DOC21/1142757-14

**EPA Advice on Revised Submissions Report – Air Quality Impact Assessment
Additional Information Still Required**

Thank you for the request for advice on 23 December 2021 from Public Authority Consultation (PAE-34237526), requesting the review by the NSW Environment Protection Authority (EPA) of the Revised Submissions Report for the Sell & Parker Pty Ltd (the Proponent) proposed Kings Park Metal Recovery and Recycling Facility Expansion (SSD-10396) (the Proposal) at 23-43 and 45 Tattersall Road, Kings Park (the Premises).

**Figure A2 Annual wind roses 2015 to 2019, Prospect AQMS**

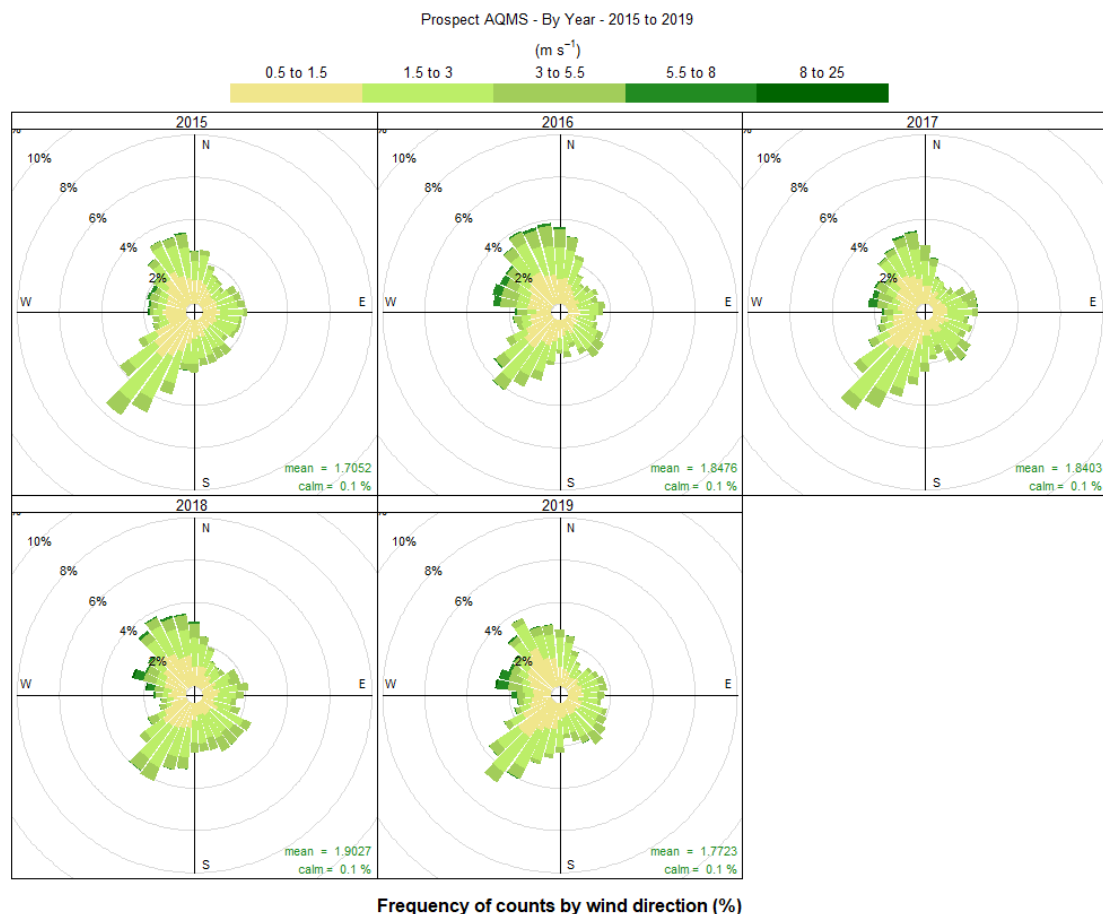
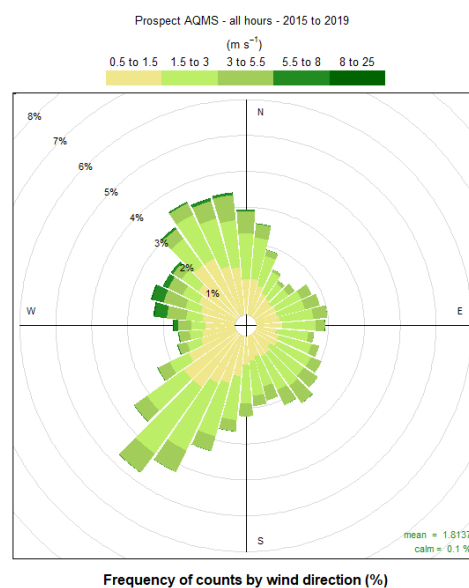
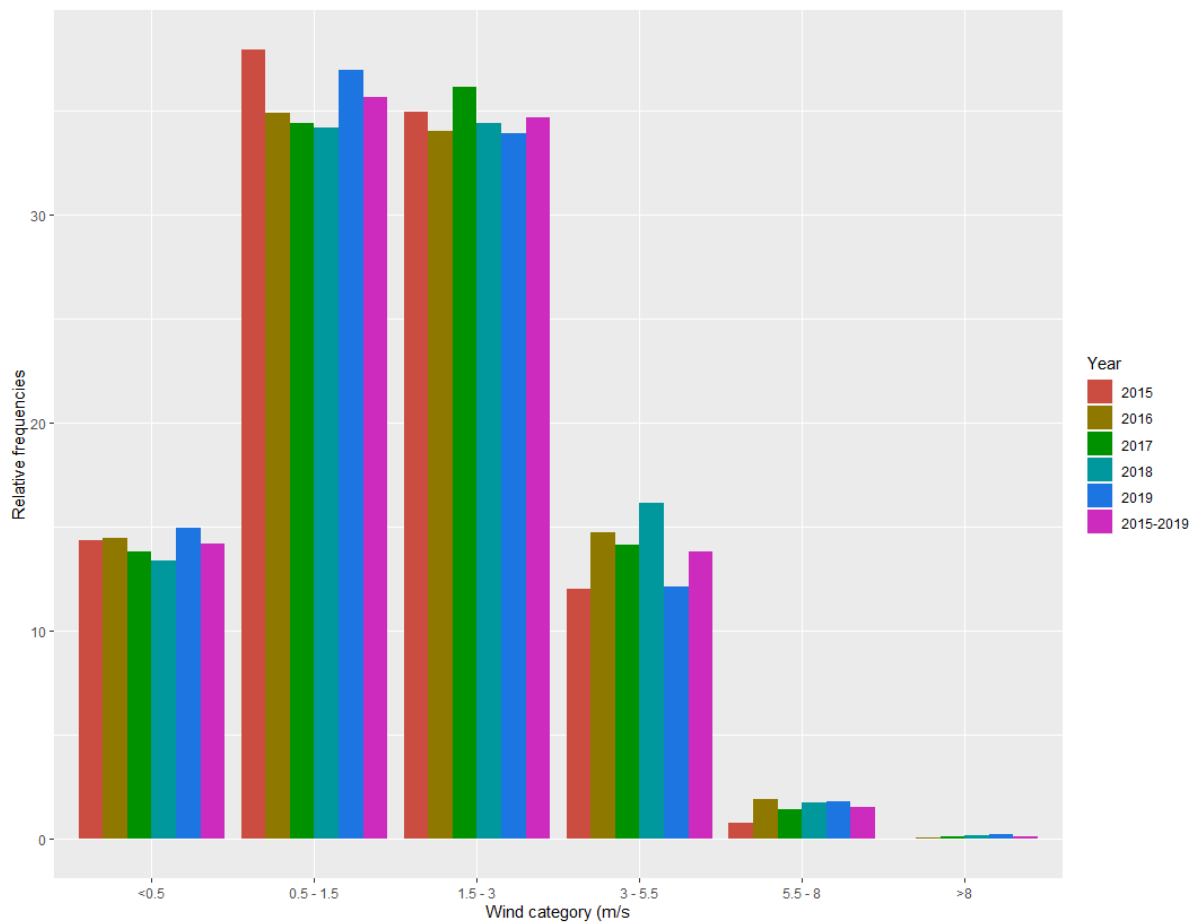
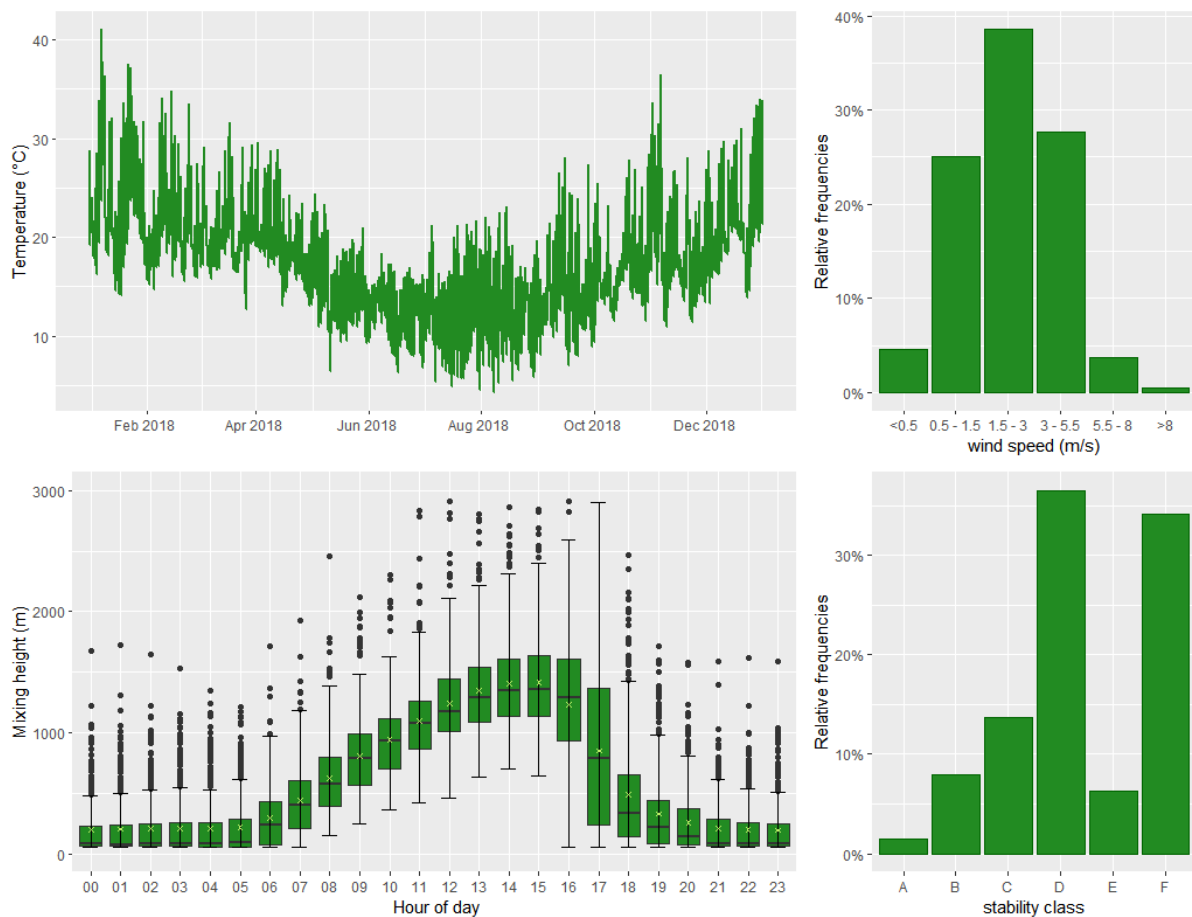
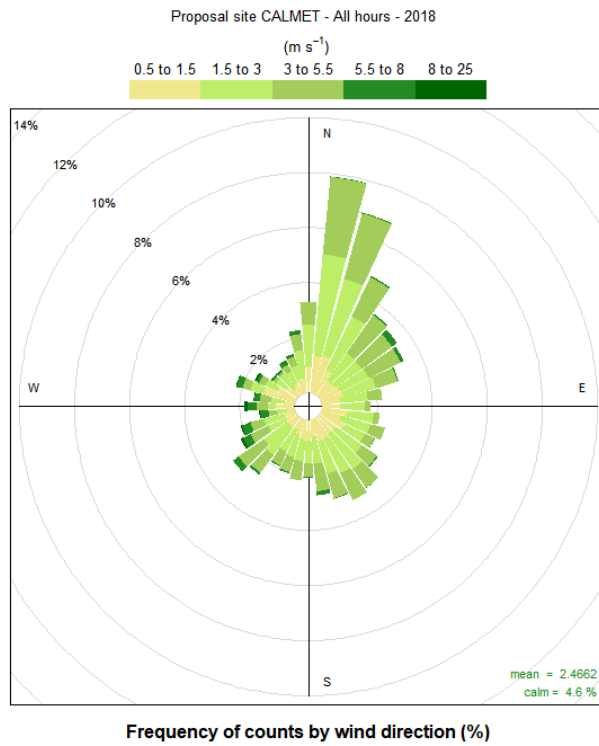
On 31 August 2021 the EPA recommended the proponent undertake quality assurance of the collected onsite meteorological data to evaluate the suitability of assimilating the onsite meteorological data in the model. The EPA recommended that should the onsite data be suitable, it be incorporated into TAPM/CALMET to generate the meteorological data or alternatively used to validate the model generated data. Alternately, the EPA recommended extracting CALMET data at Prospect to evaluate the validity of the model generated data.

This recommendation has not been addressed in the revised AQIA. The EPA recommends the proponent use the onsite meteorological data to validate the modelled meteorology.

### Isopleth Plots

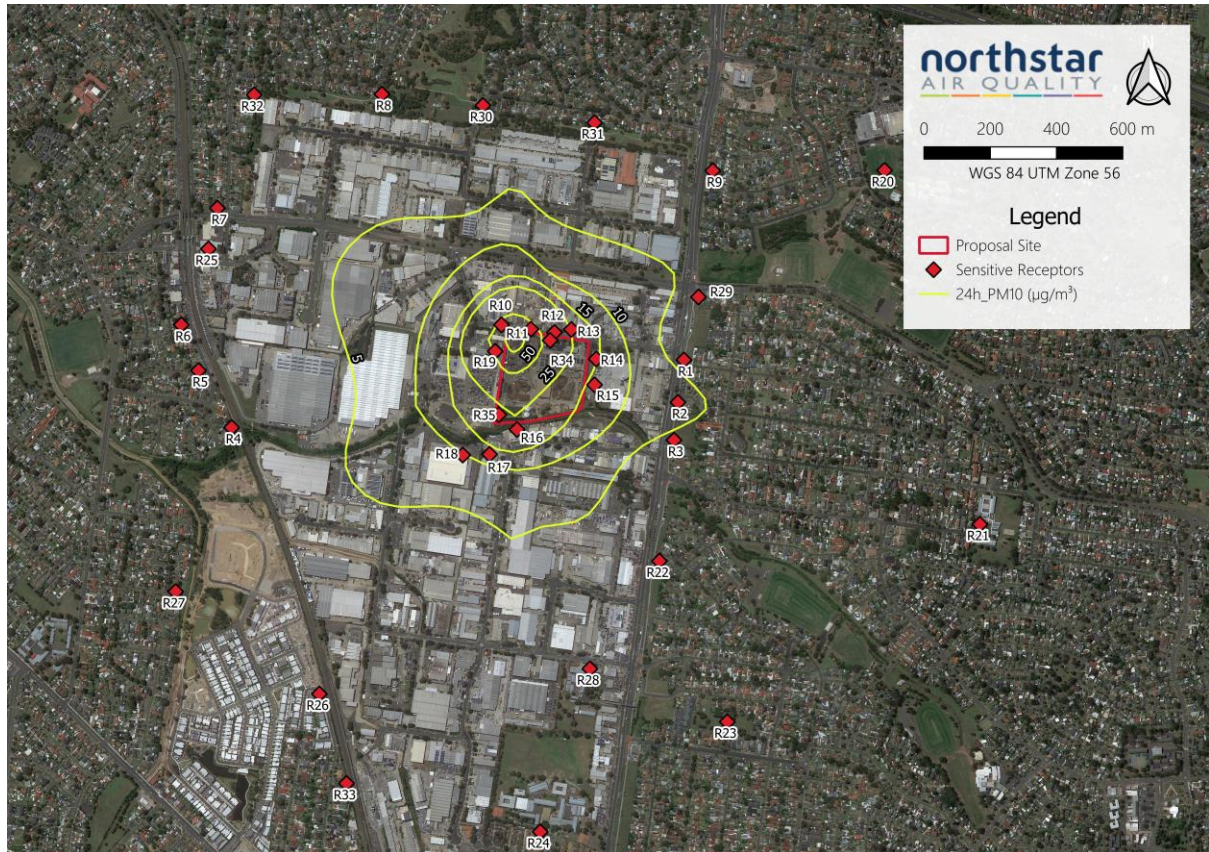
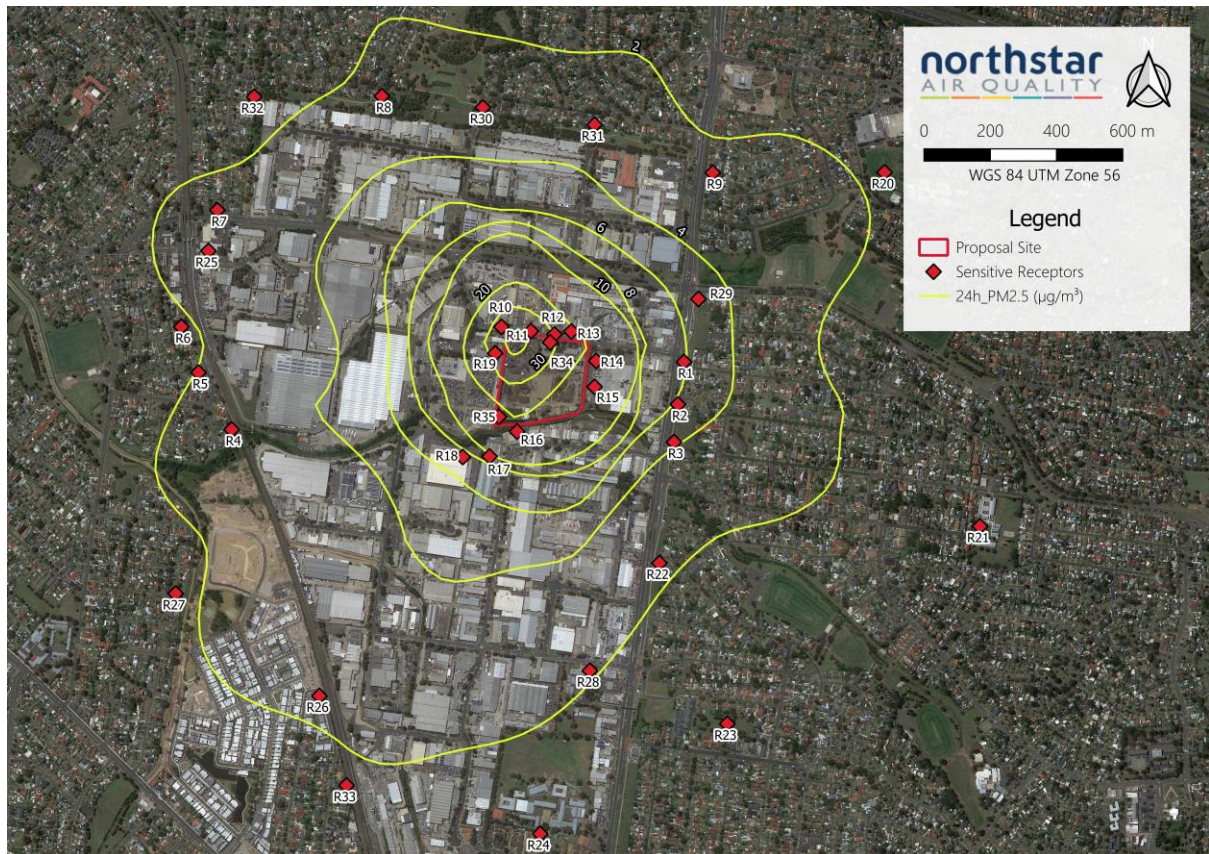
The EPA recommends that the proponent present cumulative impacts at all identified receptors. The proponent should provide contour plots of particulate impacts for transparent evaluation of impacts.
